RFI

RFI #: 203
Date: 10/30/2012
Job: EB-02 Keller Springs Lofts
Phone: 877-777-5115

Subject: Confirmation of no low roof at south entry to the west building

8.6A
AWNING DETAILS

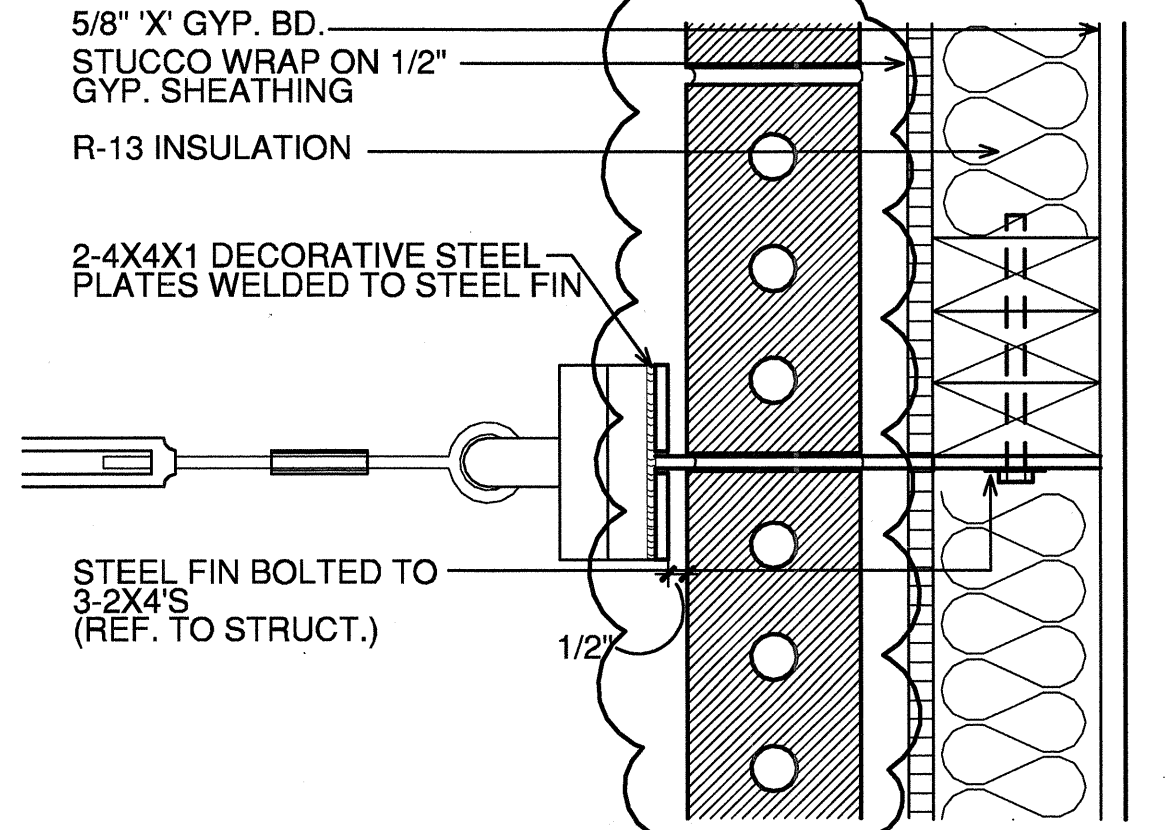
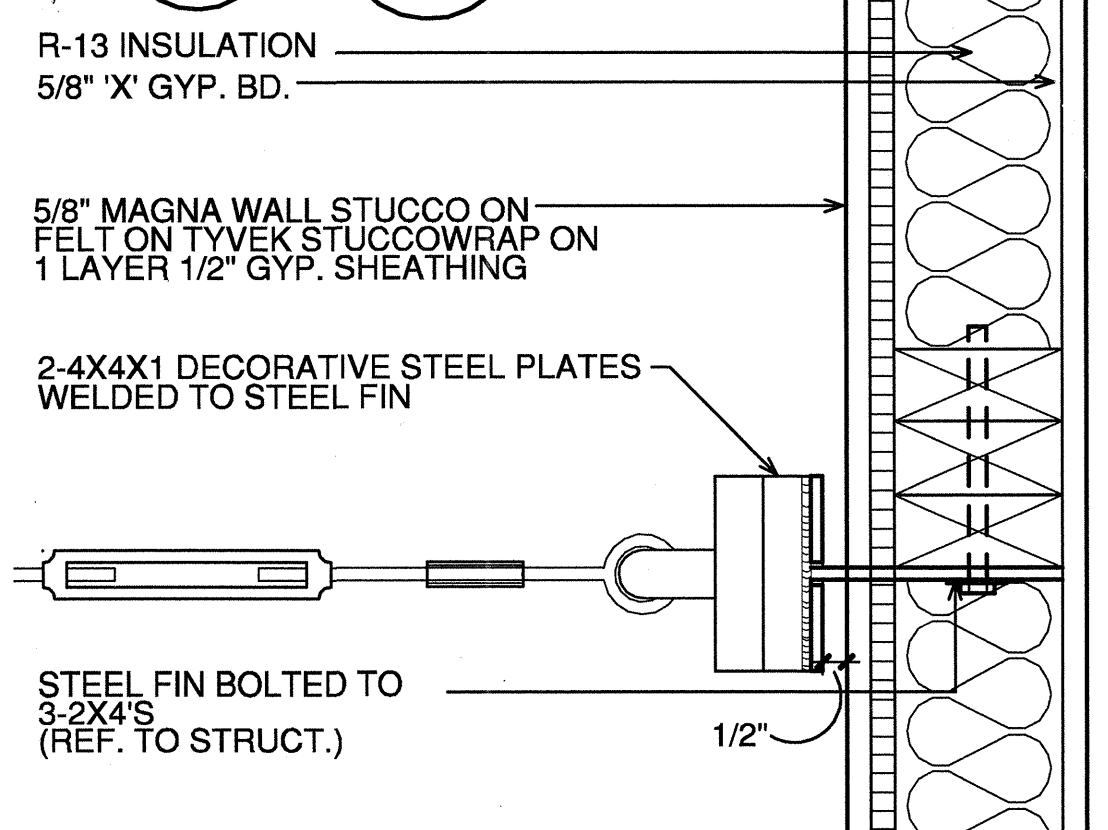
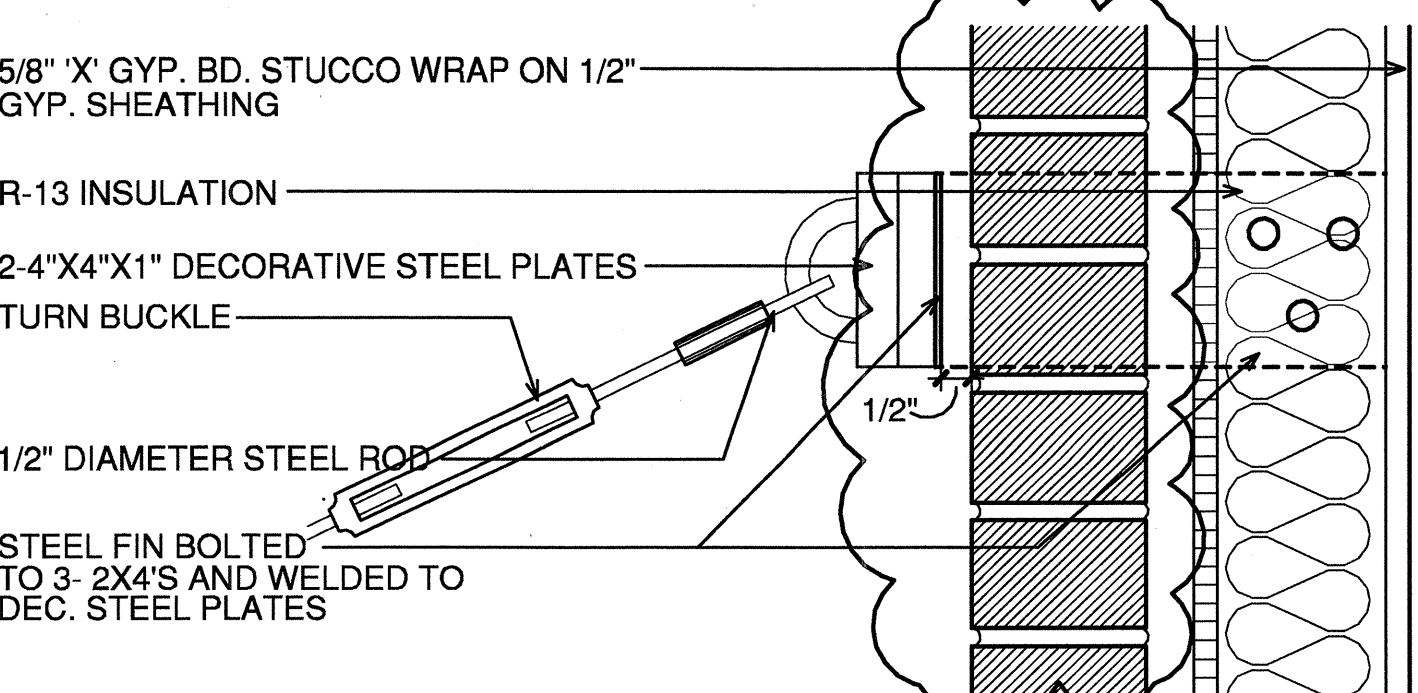
Request: **Date Required:** 11/3/2012
We need to confirm that there is no low roof at the south entry to the west building. S2.22 shows a 5 1/4" x 14" PSL D.B. & low roof framing and trusses. S2.23 shows open to below which would mean no low roof framing. S2.42 shows roof trusses with 3 1/2" x 11 1/2" D.B. Ref. 3/S5.02 which shows roof detail. 3.2B, 3.3B, & 3.4B shows open to below which would mean no low roof. 1/4.2 shows no low roof, 5/ 8.6A shows no low roof. Please confirm there is no low roof in this area.

Response:
Structure's drawing need to be updated to coordinate with architecture. The only roofs in this entry are the metal canopy on the 1st floor, and the main roof above the 4th floor. Because of RFI-035, any water that blows in behind the metal awning will fall on sloped concrete and drain away from the building.
